Subject: FW: Pevensey Road, BR/277/20/DOC

Please upload the below to the above application; Drainage Engineers comments.

Subject: Re: Pevensey Road

DETAIL A - SECTION THROUGH PERIOIOS
PAVEMENT INCORPORATING POLYPIPE
PERMAVOID SUB-BASE REPLACEMENT
AND INFILTRATION SYSTEM

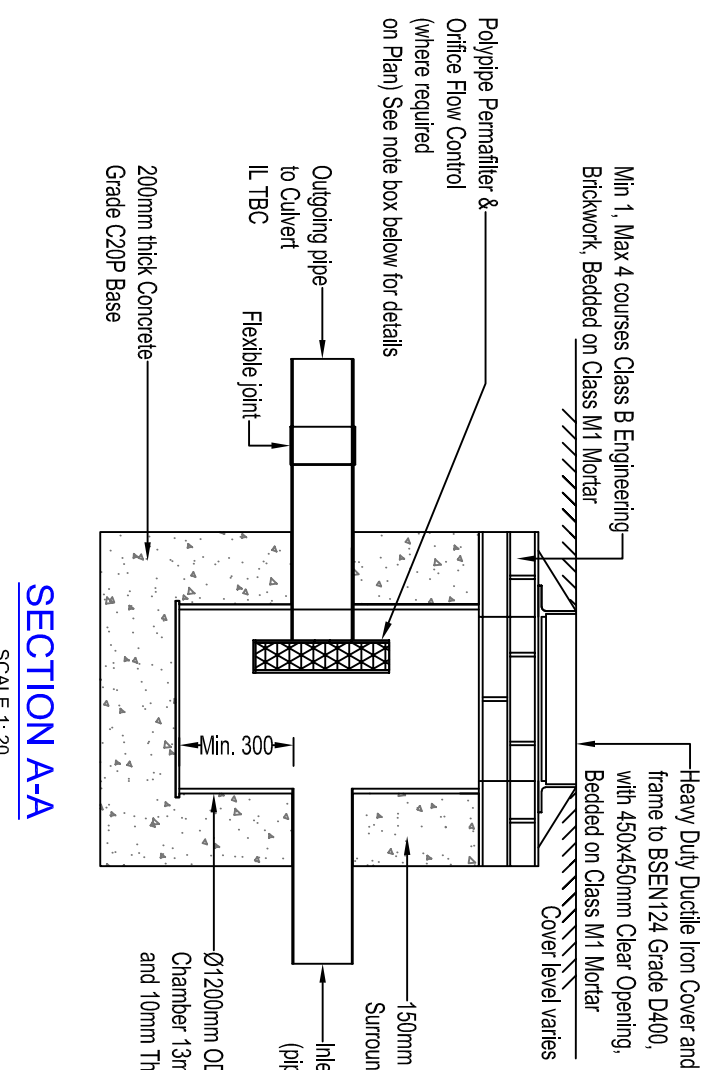
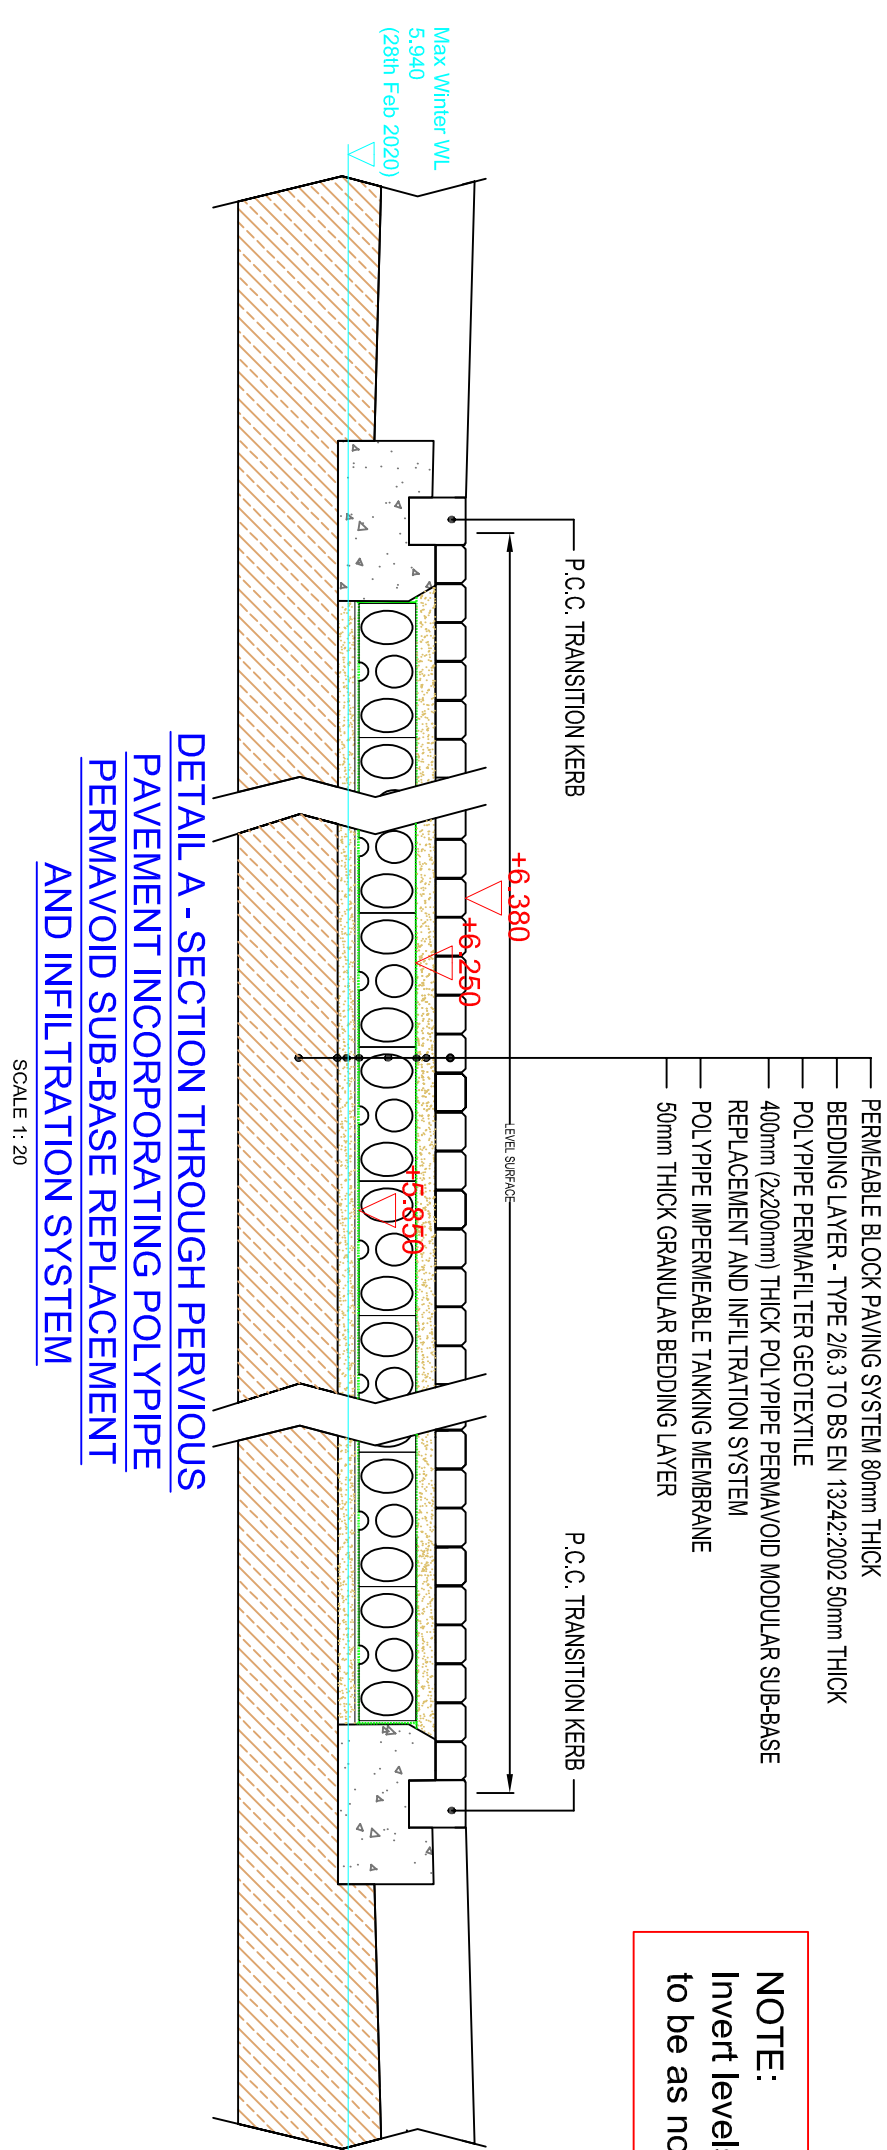
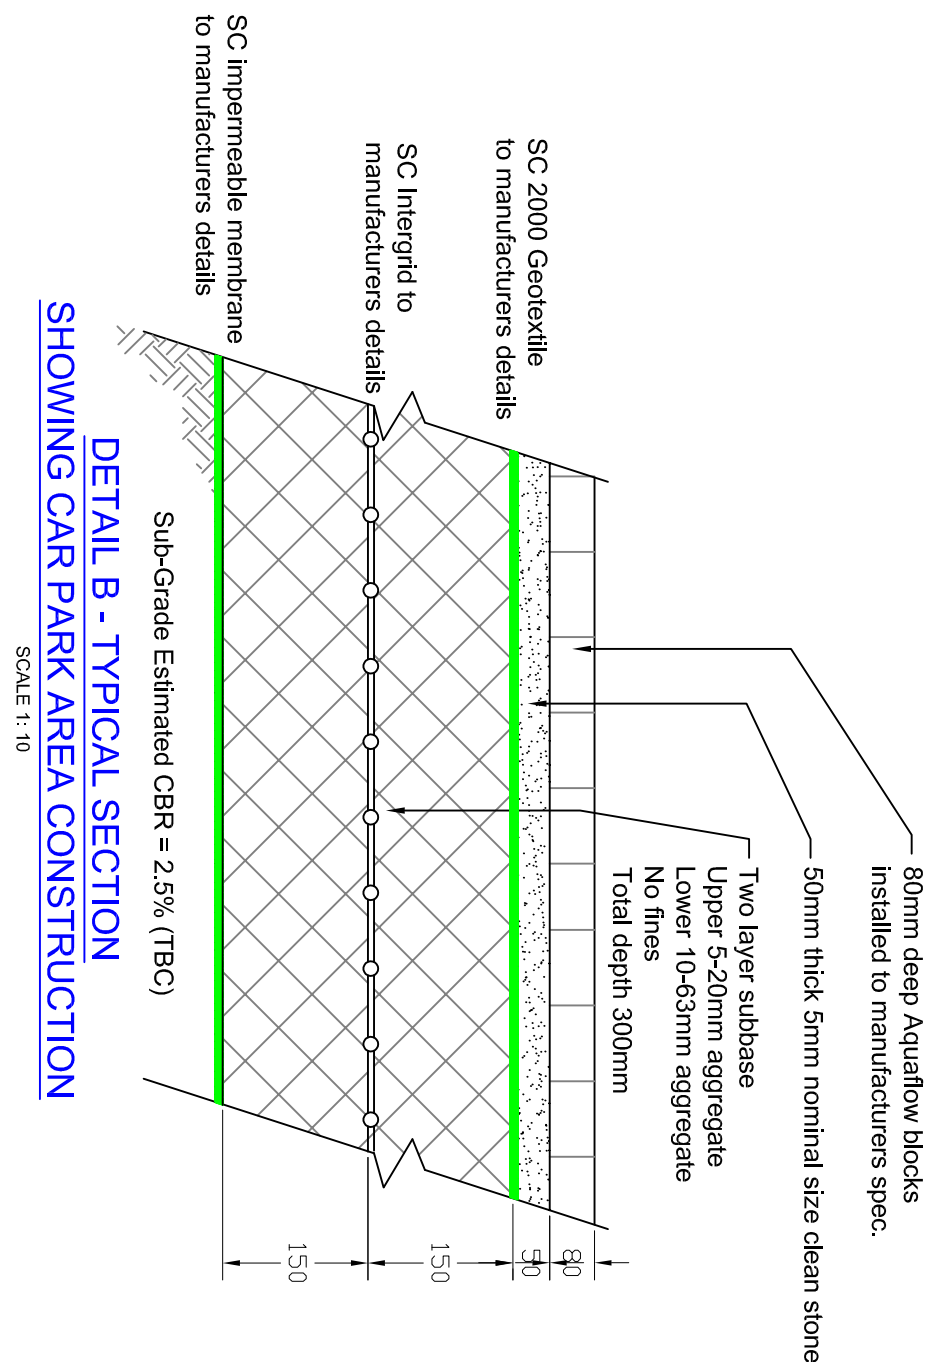
5. I note that the invert level of the outlet is 5.8m, yet the base level of the storage is 5.85. Please detail how this is going to work.
6. The invert level, cover level and unit reference of the hydrobrake must be referenced on both the plan and construction detail drawings and be consistent with that in calculations.

7. Please provide construction detail drawings which show the means of connection to and from the sub-base.
8. The invert level of the existing system that you propose to connect to must be known.

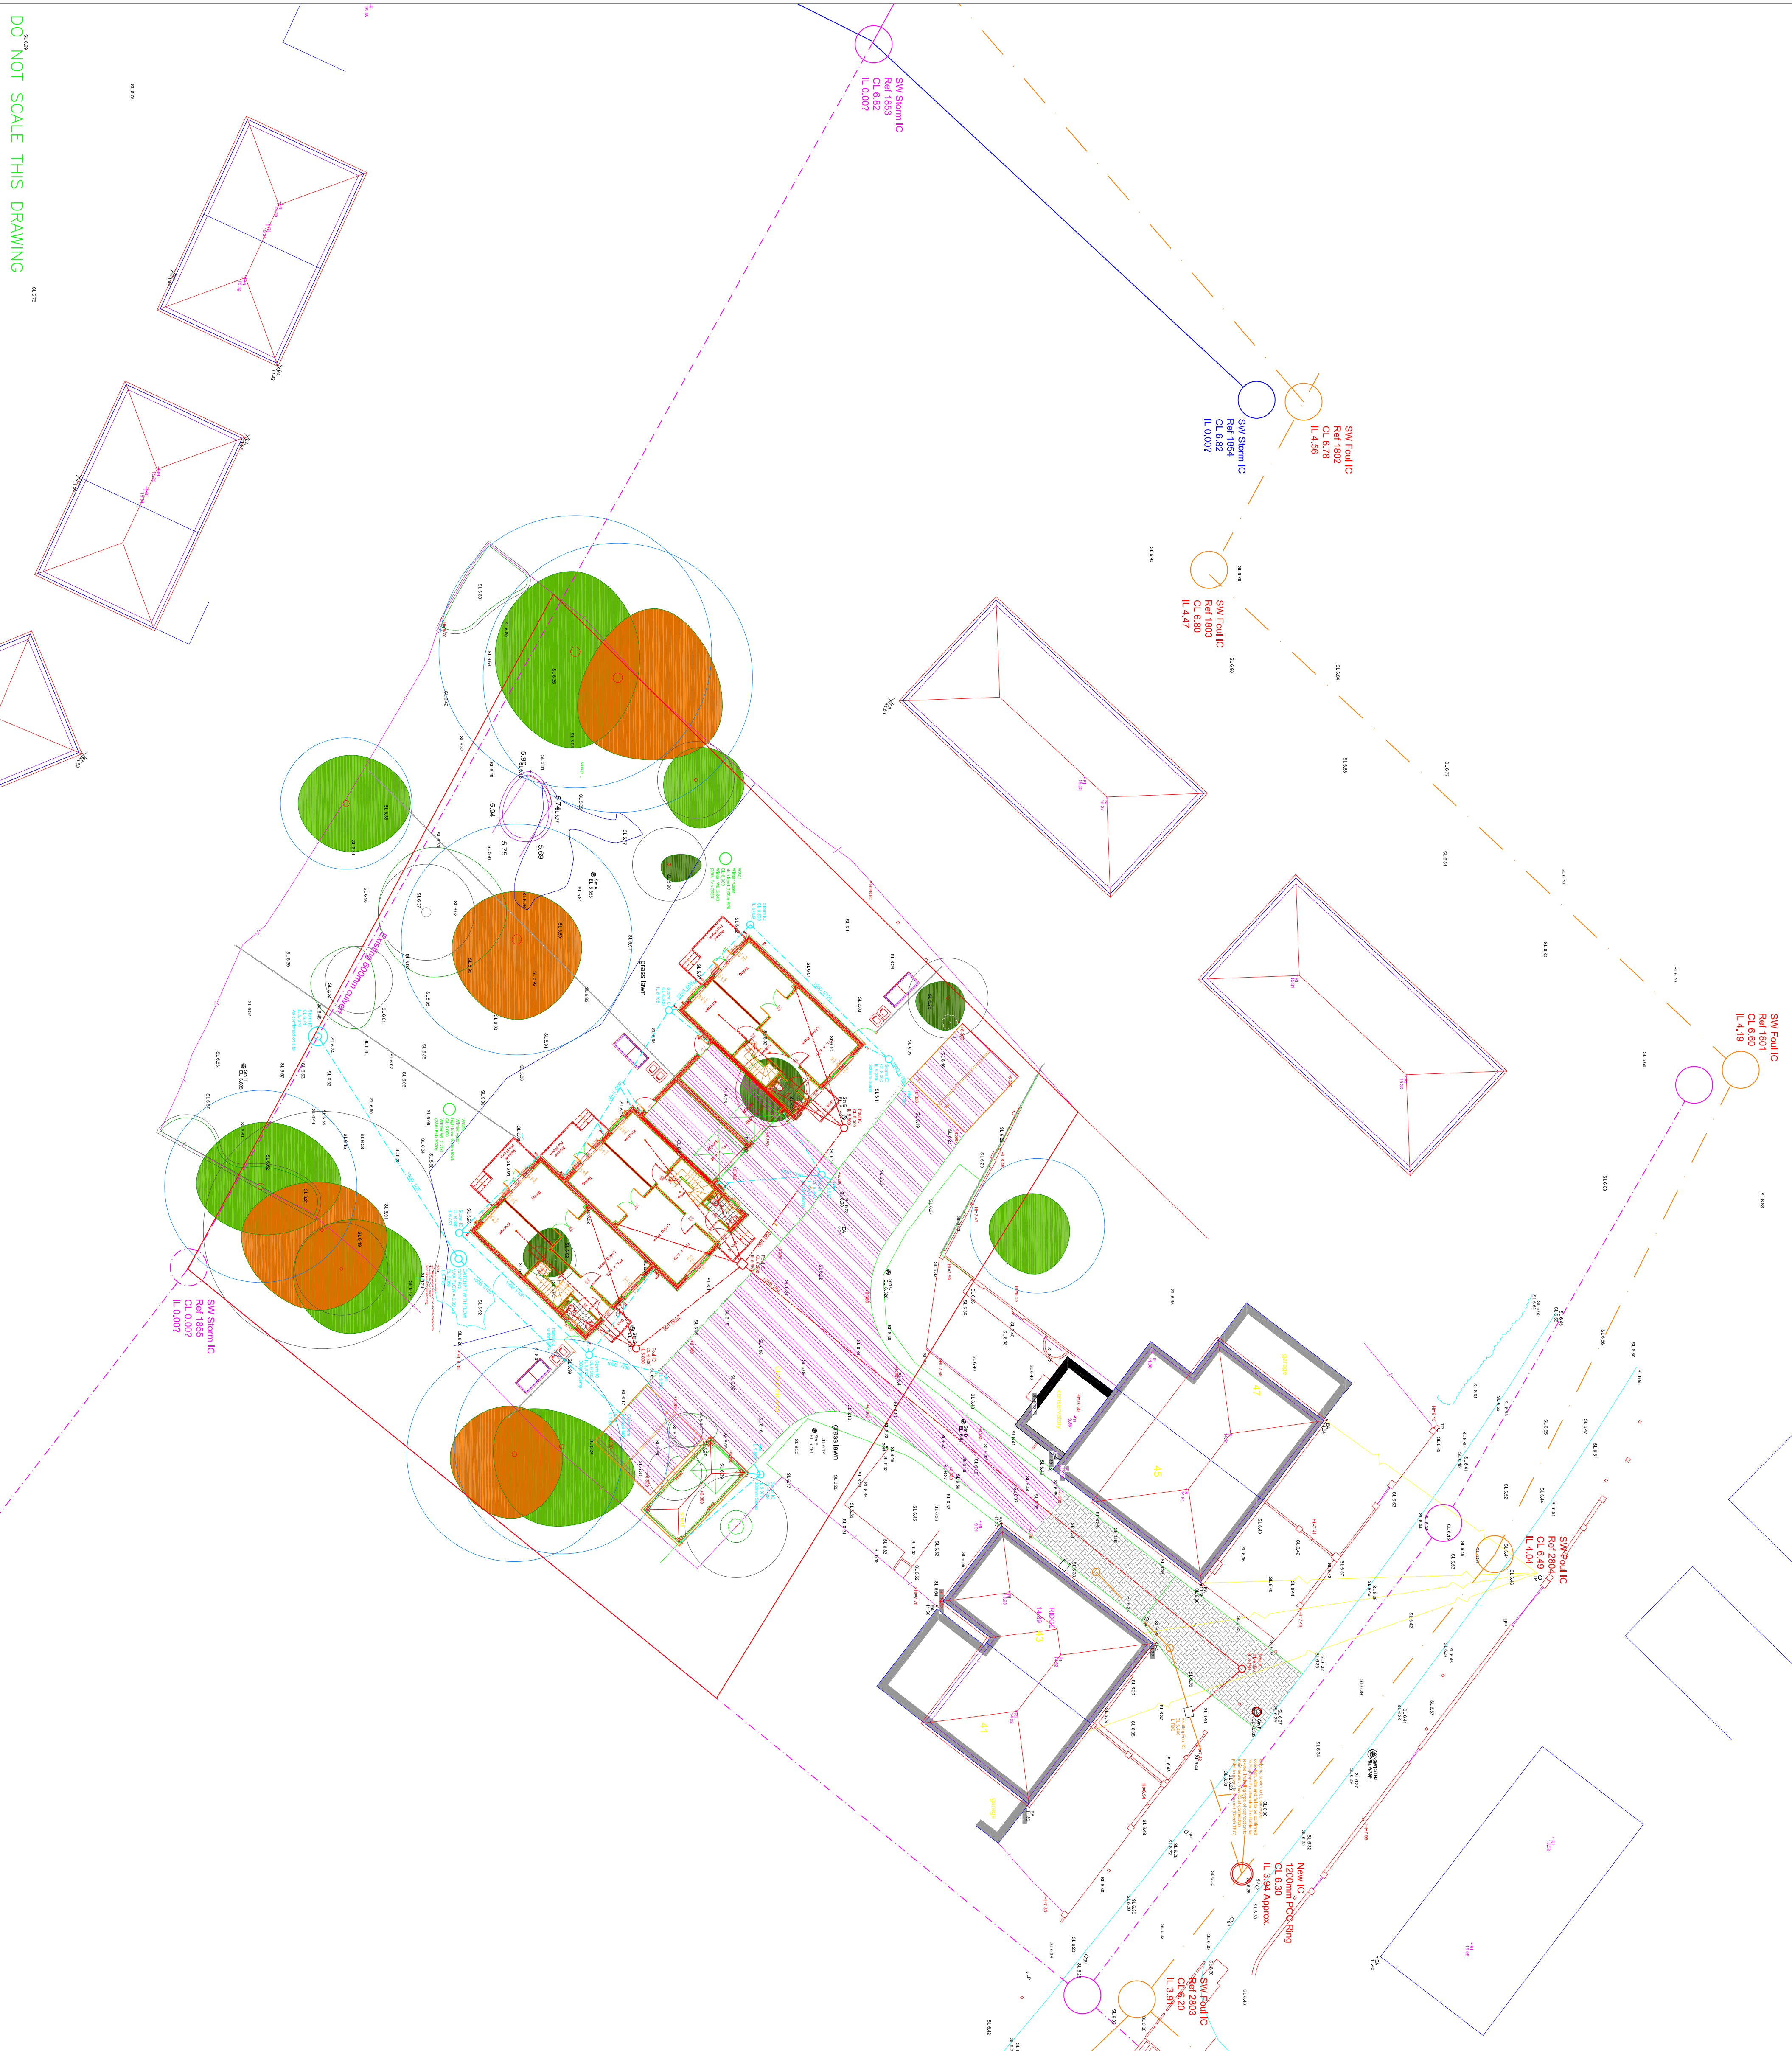
1. FEH rainfall or a Cv of 1 must be applied to calculations.
2. Nodes and pipe numbers should be labelled on plan to correspond with the modelled network to facilitate review. The flow file would also help my review, if possible please include this in your revised package of information.

3. I note a flow through pond structure has been modelled with an area of 487m², it is presumed this has been modelled to replicate the crates under the permeable paving. Please confirm this area is provided on the drawing. Ideally please supply the drawing in dwg format to enable independent paperless verification.
